REFUSAL OF PLANNING PERMISSION

APPLICATION NO. 2014/0842

Proposal Formation of a new front door opening.

At 3 High Street, Dodworth, Barnsley, S75 3RF

PROPOSED FRONT ELEVATION

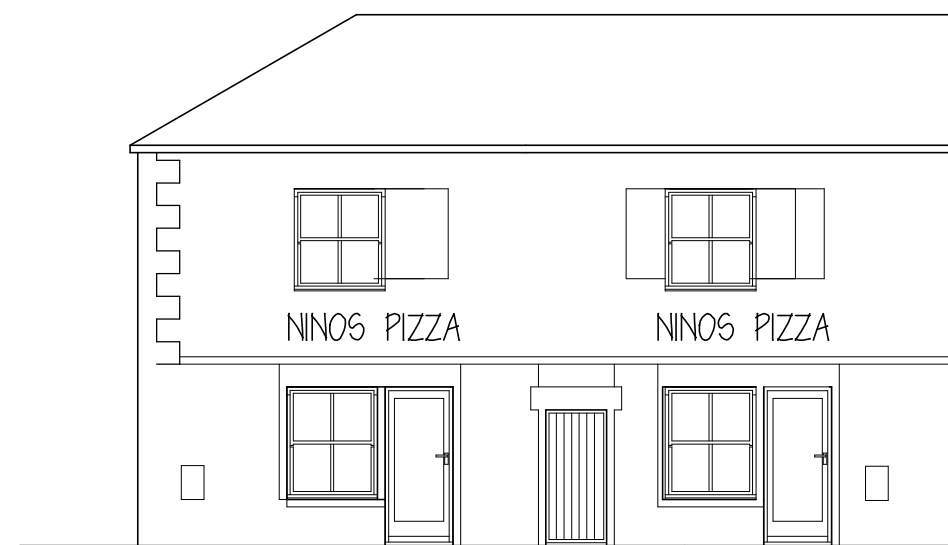
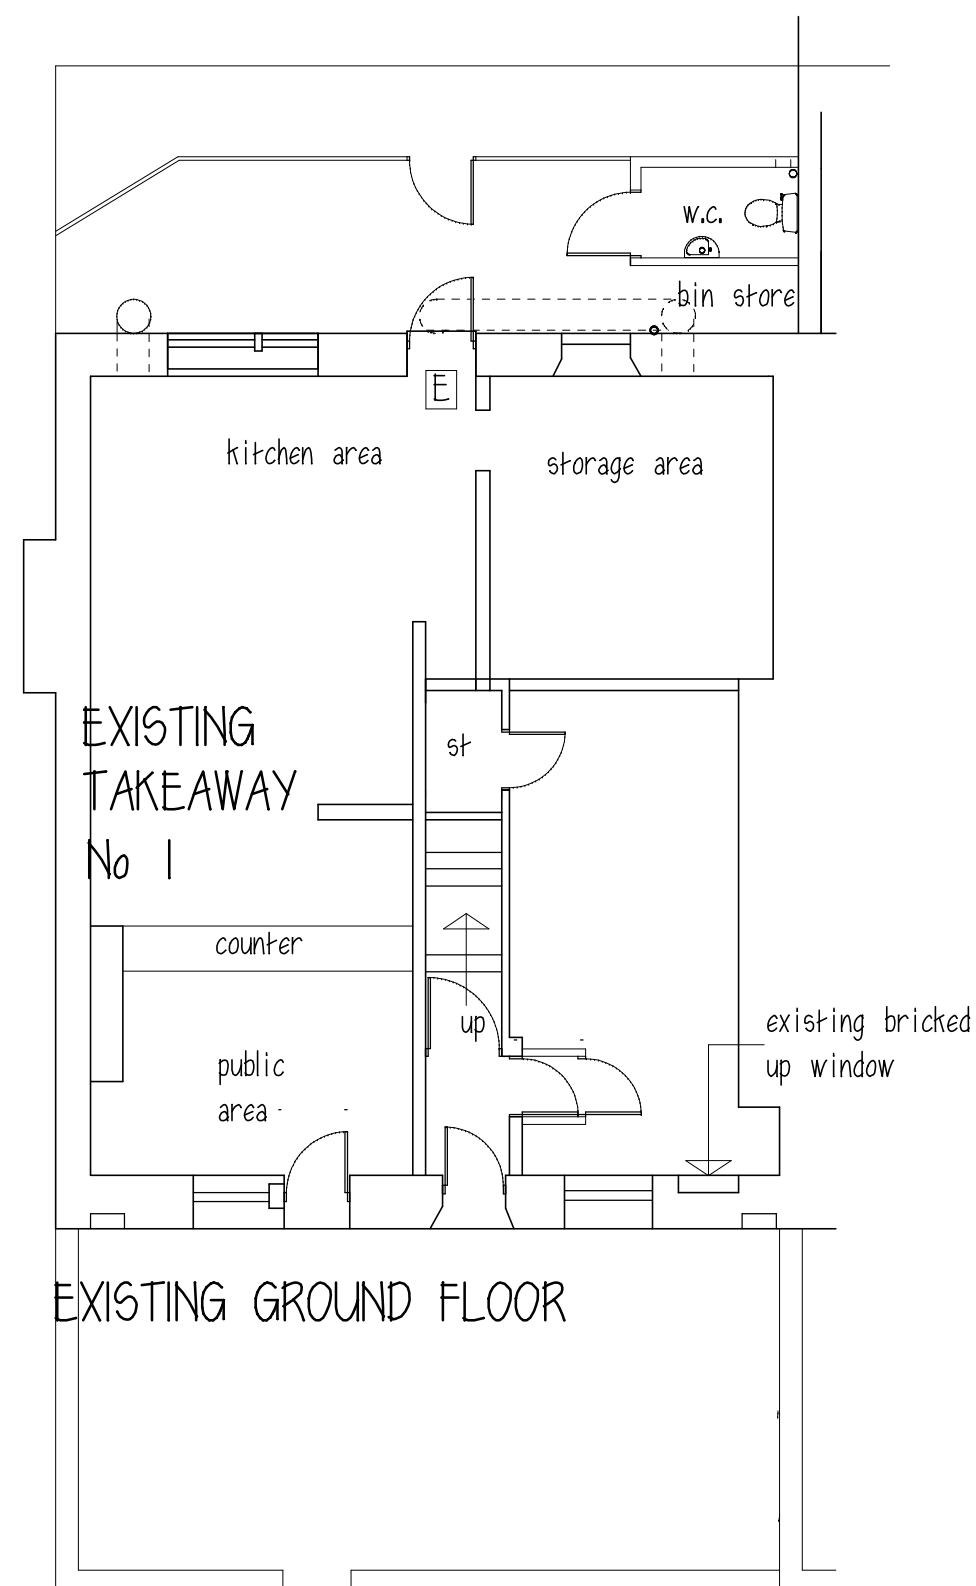
- 1 The addition of a third door to the front elevation of the Listed Building would appear odd and unbalanced and due to the alterations already taken place, it is not felt that the exterior of the building can accommodate any further modifications without prejudicing its special historic or architectural character. The proposals are therefore contrary to the NPPF and policy CSP30 of the Core Strategy.
